U-HAUL AT FALCON - ROLLING THUNDER WAY

SITE DEVELOPMENT PLAN

FALCON U-HAUL FILING NO. 1 (FALCON HIGHLANDS)

PCD File # PPR-22-56

SHEET CONTENTS:
CIVIL SITE PLAN

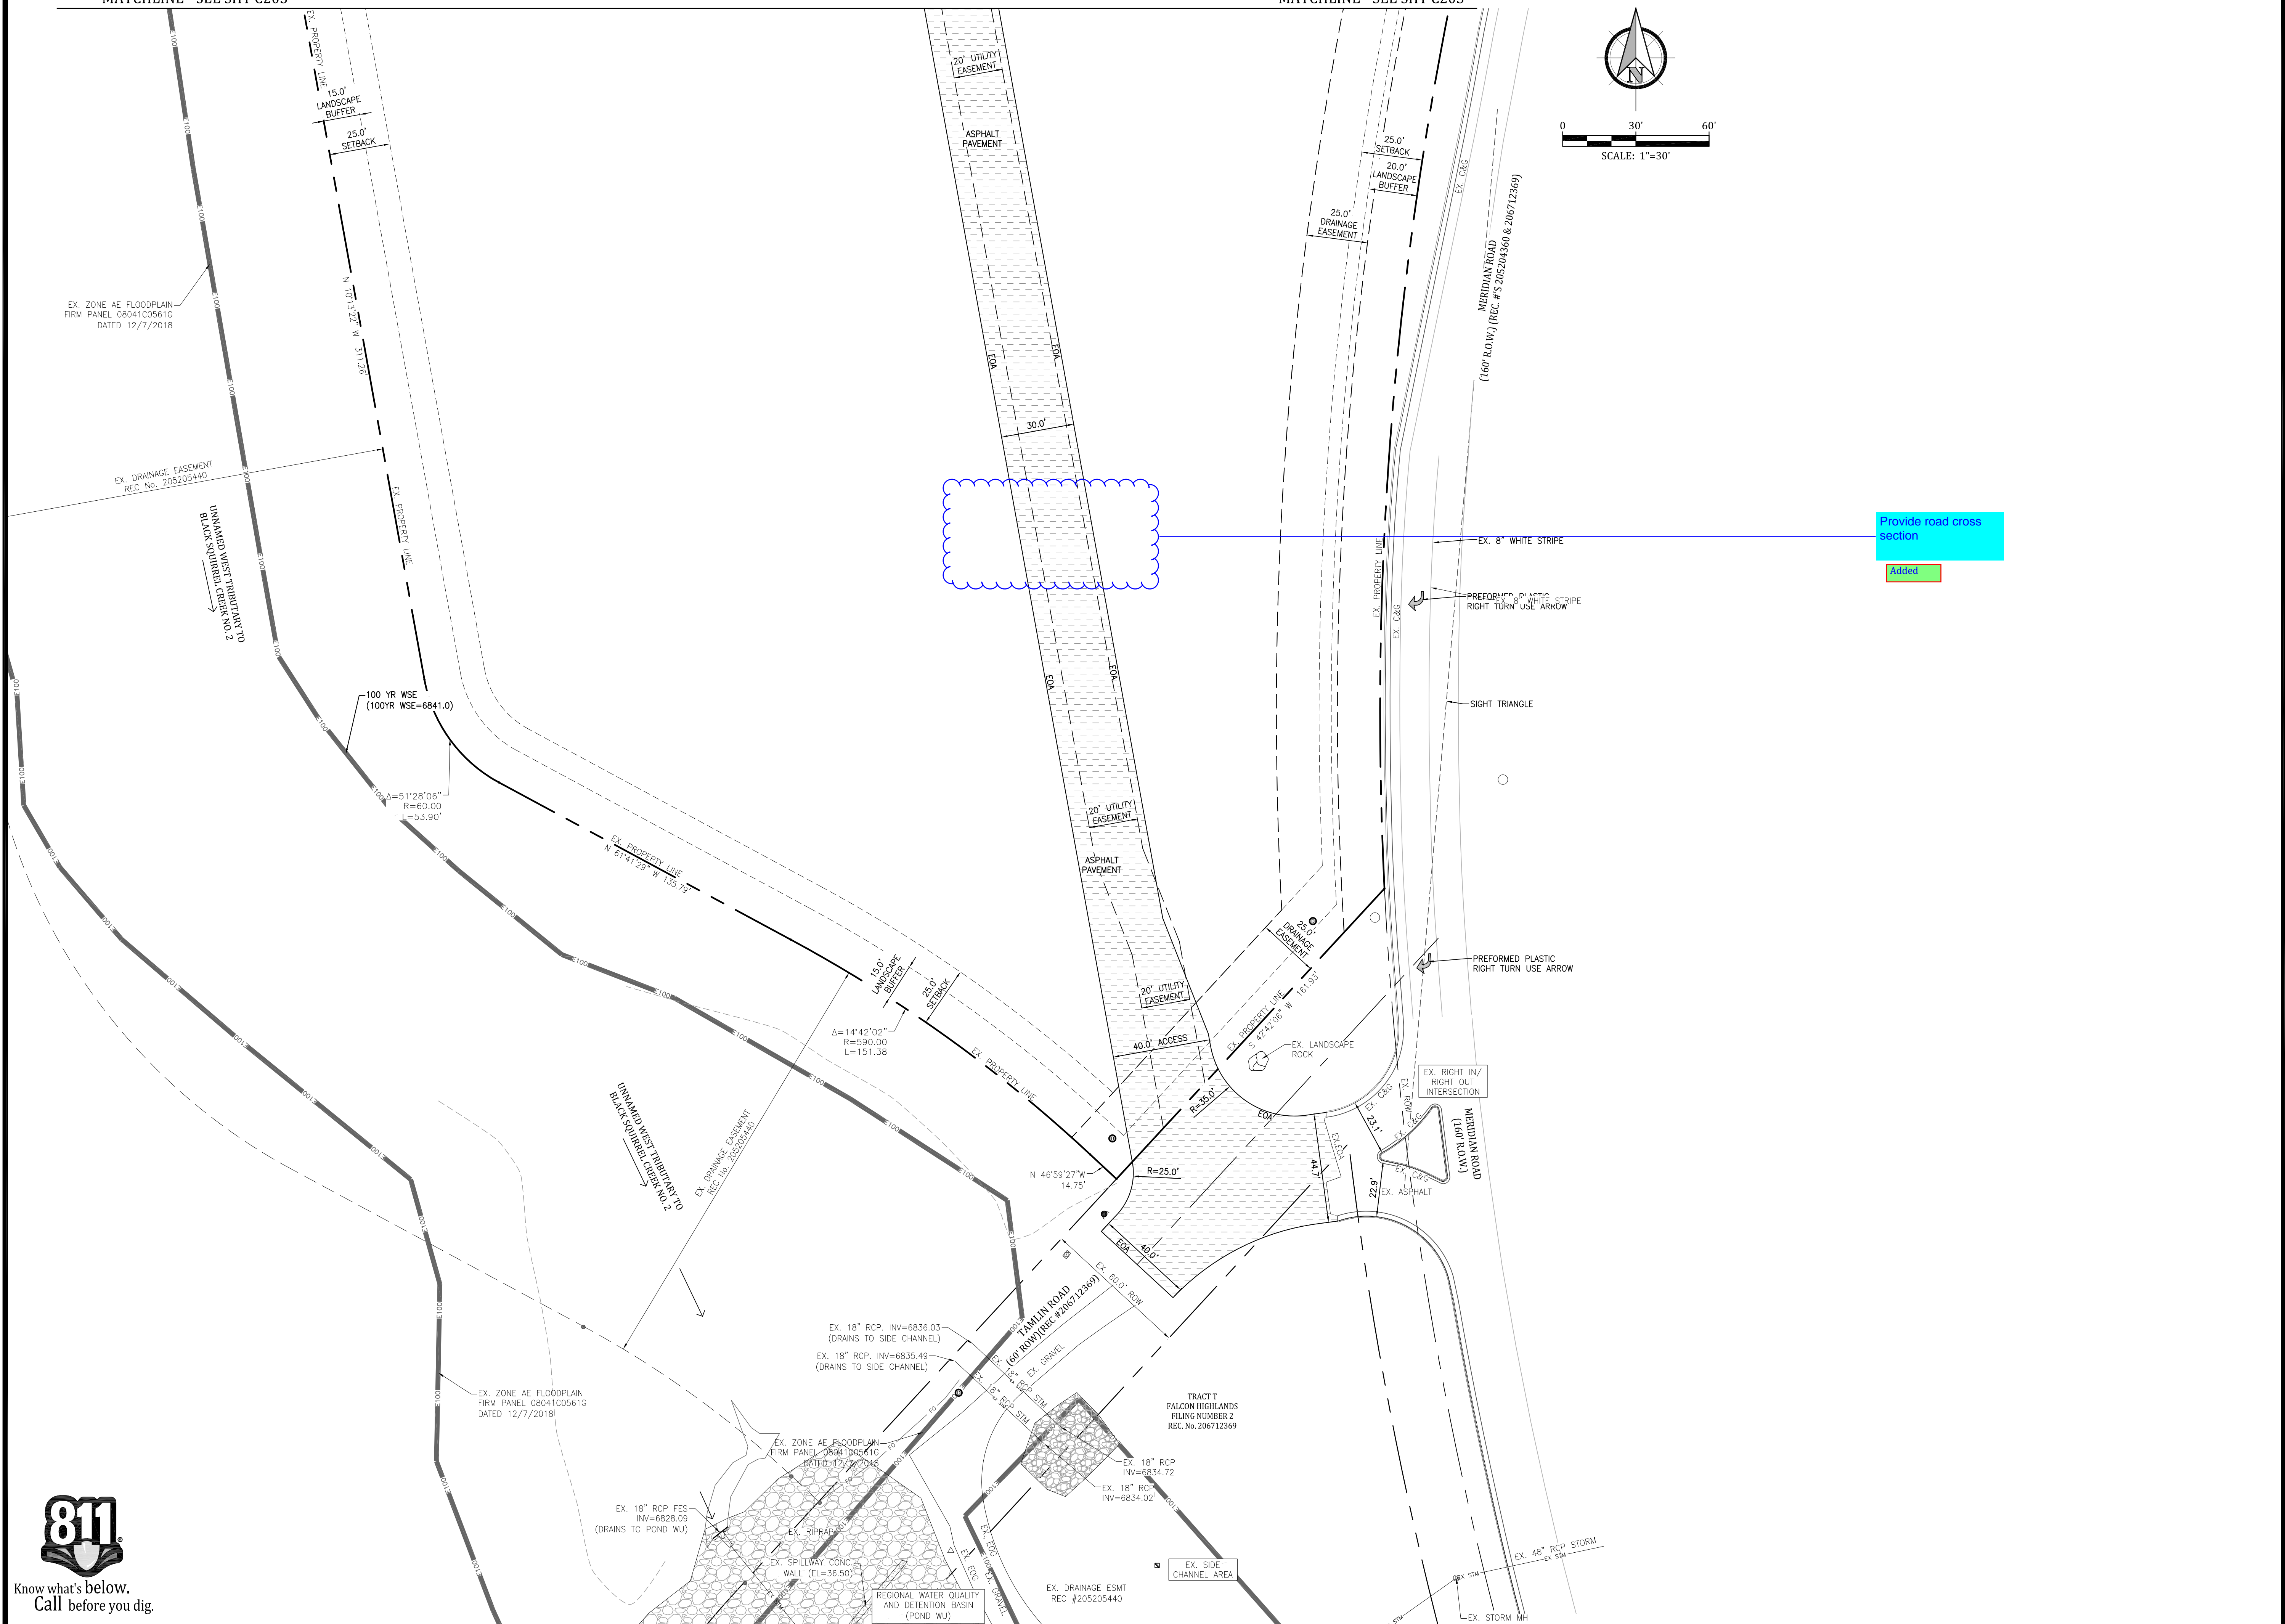
Will there be a dumpster / trash enclosure located on this site? None has been noted on this plan. Graphical depiction of screening mechanism is also required.

You have only provided calculations for the auto sales / display. Please also provide parking calculations for mini-warehouse. 1 space per 100 units, plus 1 space per employee

Show property line as solid line and correct legend

Provide sidewalk along Meridian Road Frontage

DRAWN: JRD
 CHECKED: MWE
 DATE: 8/26/22
C401

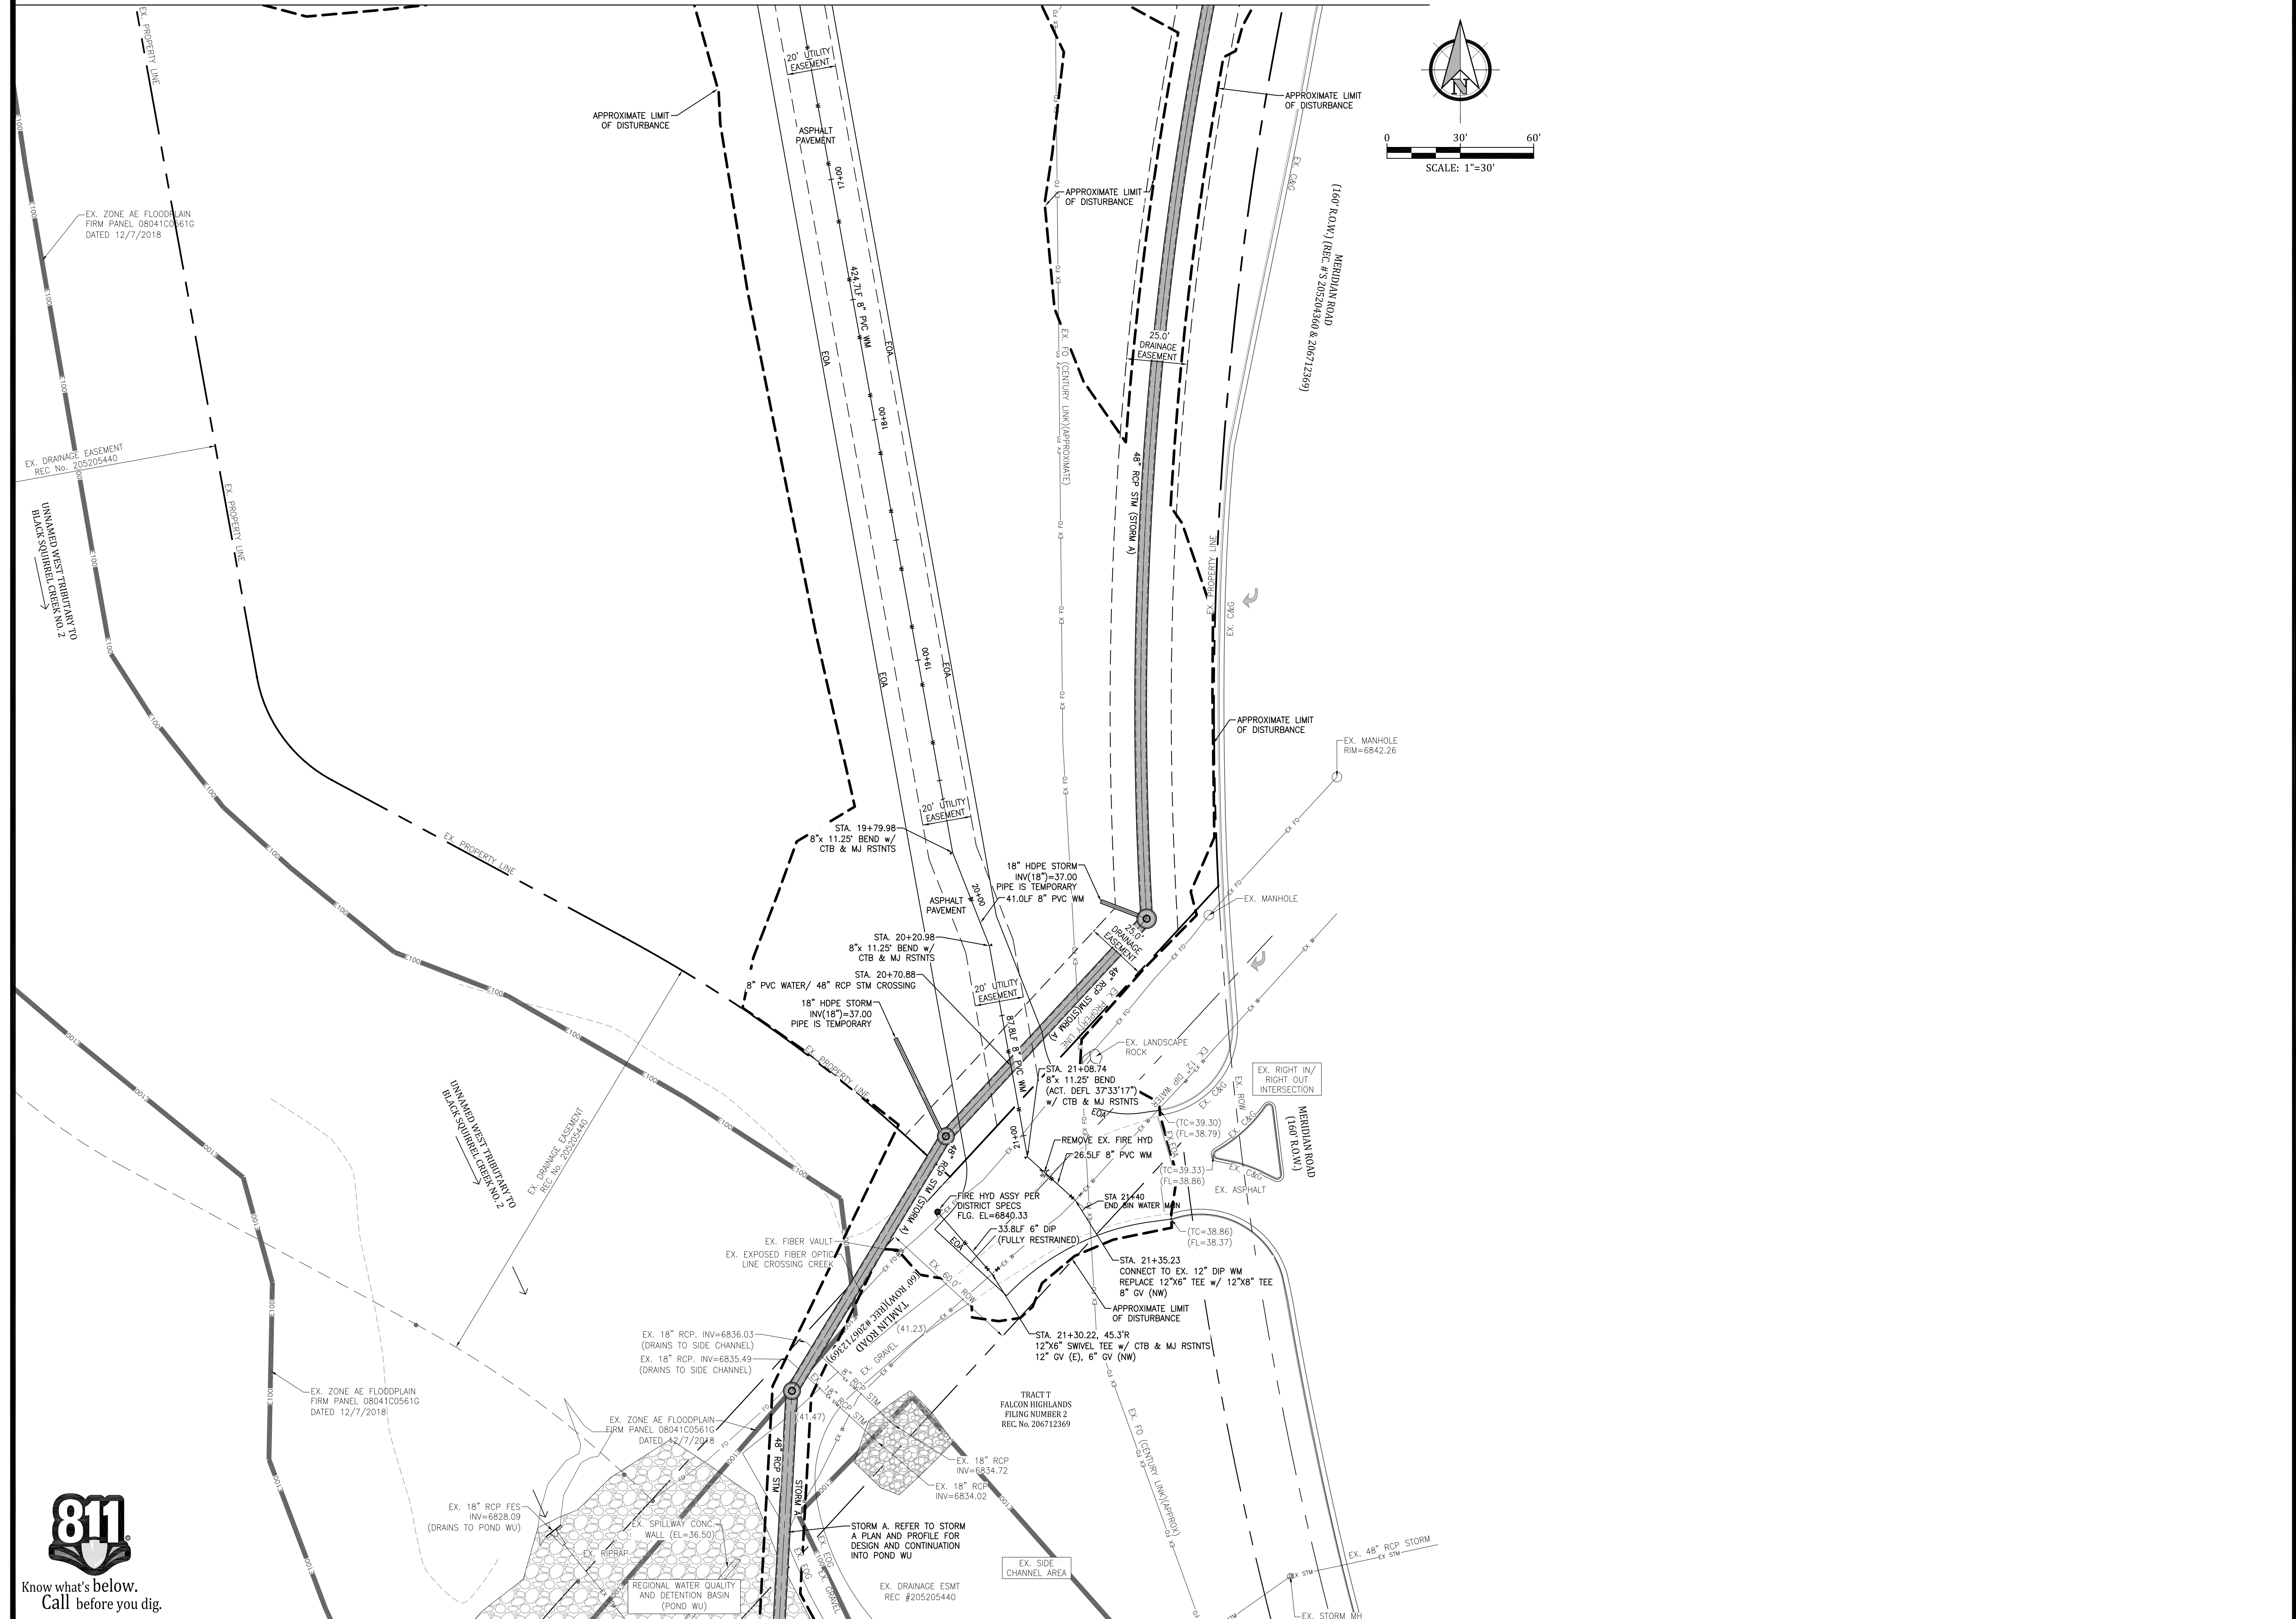
Please show existing drainage easement to be vacated with call out note

Missing
Location of all garbage receptacles with a graphical depiction of the screening mechanism

Add Stop Sign
